January 14, 2018

Re: McCune Ranch Subdivision, City of Colorado Springs, Preliminary Drainage Report Review #1

PRELIMINARY PLAN SET
MCCUNE RANCH SUBDIVISION
 A PARCEL OF PROPERTY LOCATED IN SECTIONS 13 & 24, TOWNSHIP 11 SOUTH, RANGE 65 WEST OF THE 6TH P.M. AND IN THE WEST HALF OF THE WEST HALF OF SECTION 19, TOWNSHIP 11 SOUTH, RANGE 64 WEST OF THE 6TH P.M., COUNTY OF EL PASO, STATE OF COLORADO

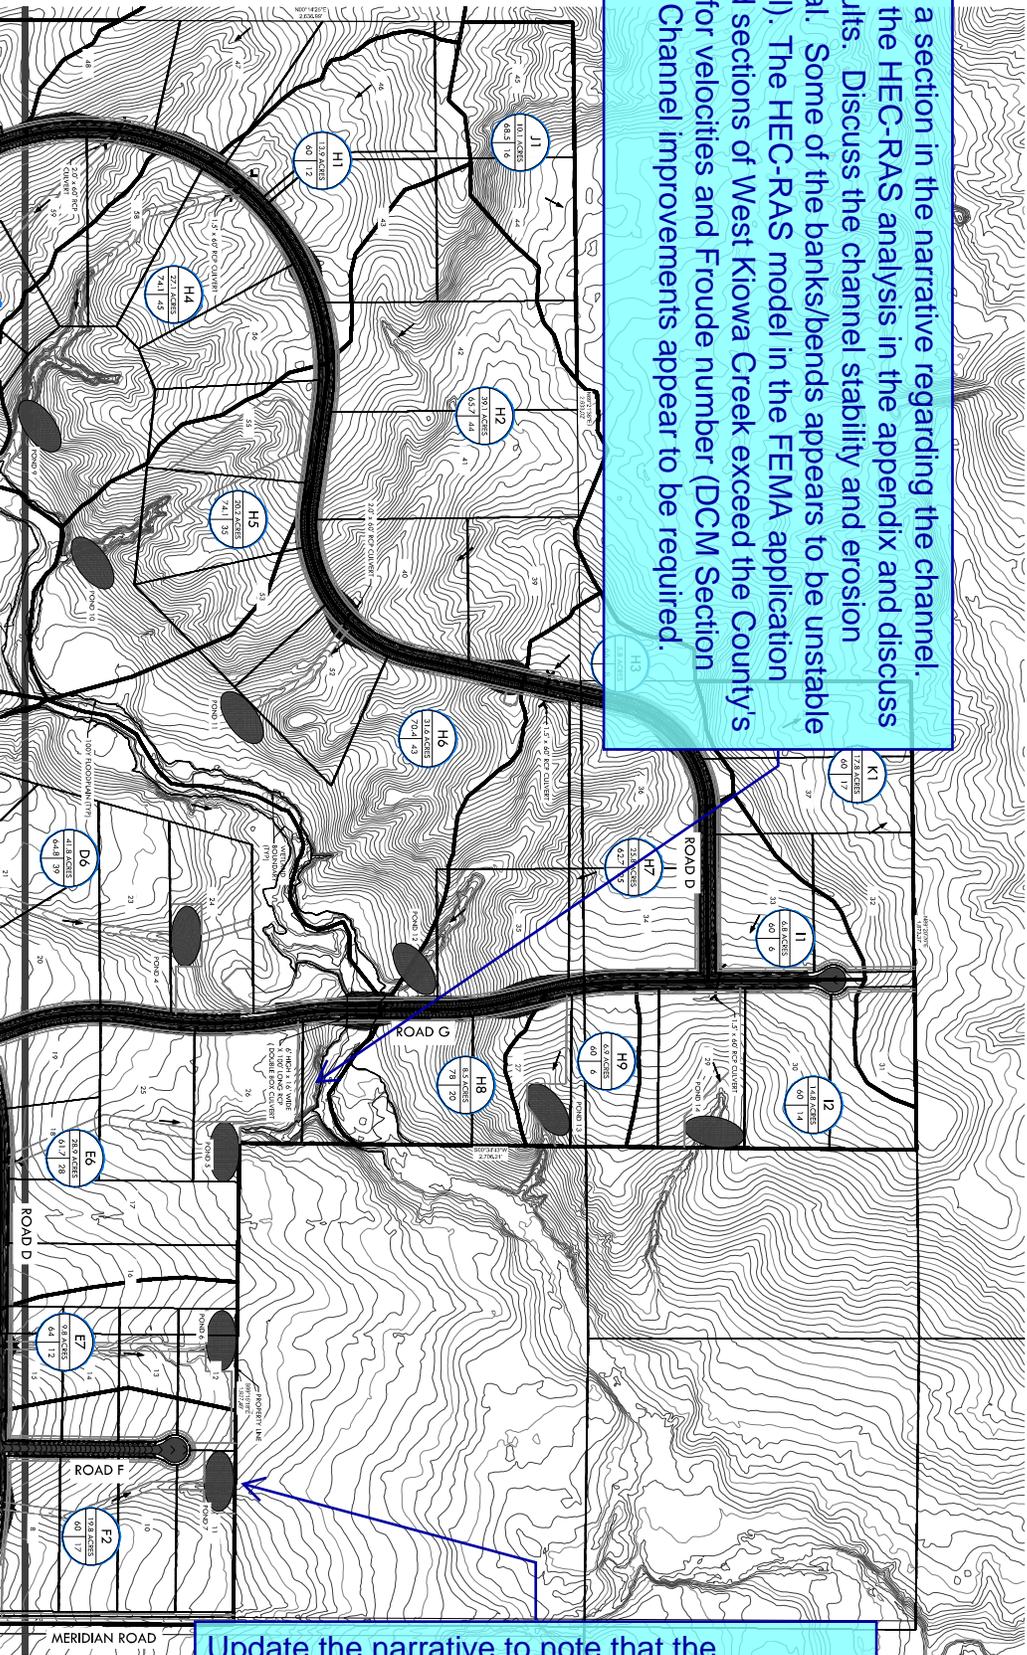
- g. Include a section in the narrative regarding the channel. Include the HEC-RAS analysis in the appendix and discuss the results.  
**Response: Acknowledged.**

- h. Discuss the channel stability and erosion potential. Some of the banks/bends appears to be unstable (vertical). The HEC-RAS model in the FEMA application showed sections of West Kiowa Creek exceed the Country's, criteria for velocities and Froud's number (DCM Section 6.5.2). Channel improvements appear to be required.

**Response: Pond outfalls will be addressed in the final drainage report.**
- j. Fix spelling of Berm.  
**Response: Complied.**
- k. Revise the 100 year delineation. The line type used is too similar to the contours.

**Response: Complied.**
- l. Roadside ditch analysis will be required with each final drainage report. Part of the analysis will need to identify the lots that will need driveway culverts greater than the standard 18" diameter and identify the required culvert size.

**Response: The full FEMA report is being uploaded with all the HEC-RAS modeling. A Prudent Line Analysis has also been completed.**
- i. Update the narrative to note that the subsequent Final Drainage Report will analyze the segment between the pond outfall to the main channel (West Kiowa Creek). Offsite improvements may be required if the segment from the outfall to the stream is not hydraulically adequate.

**Response: Ditch capacity and culvert sizing will be addressed in the final drainage report.**
- m. Add drainage channel and easement.  
**Response: Complied.**
